From: Nicola Moore
Sent: 23 March 2020 14:20
To: 'Jeff Robertson'
Subject: RE: 75 Mead Lane, Bognor Regis, PO22 8AP

Thank you for the attached plans and CIL firm.

FIRST FLOOR PLAN

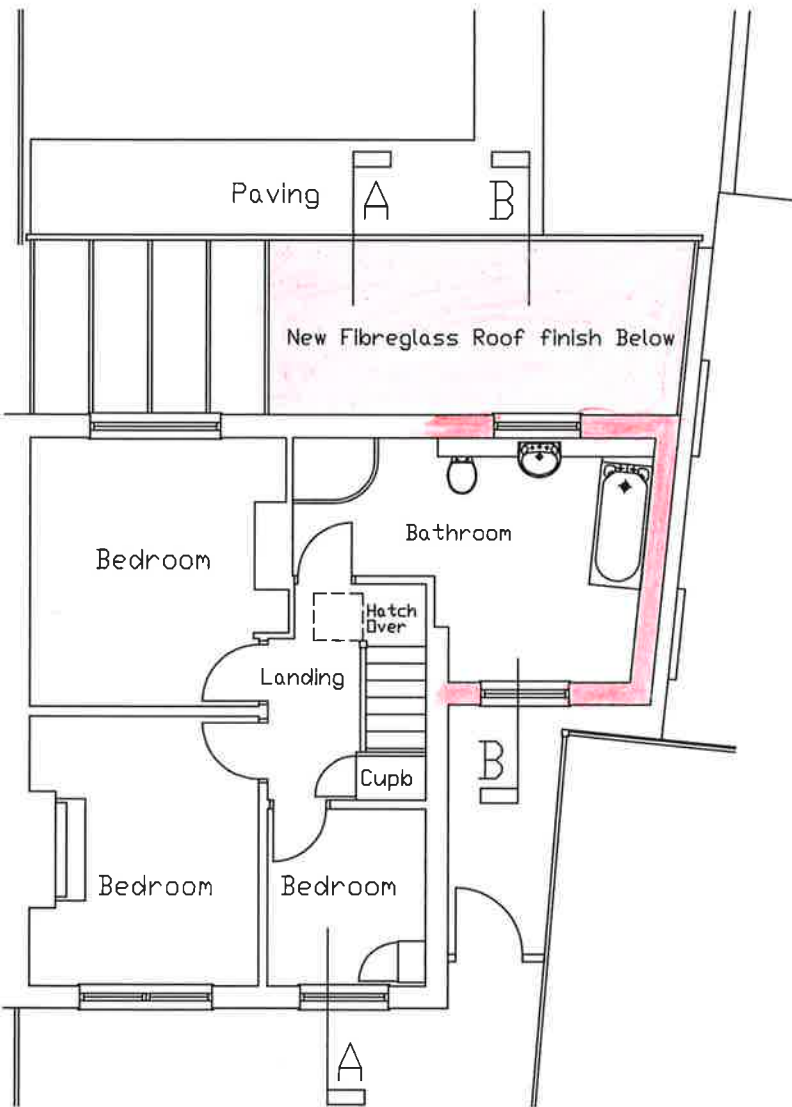
For clarity, please can you confirm if the door that is shown on the proposed first floor plan is a door or a side access at ground level.
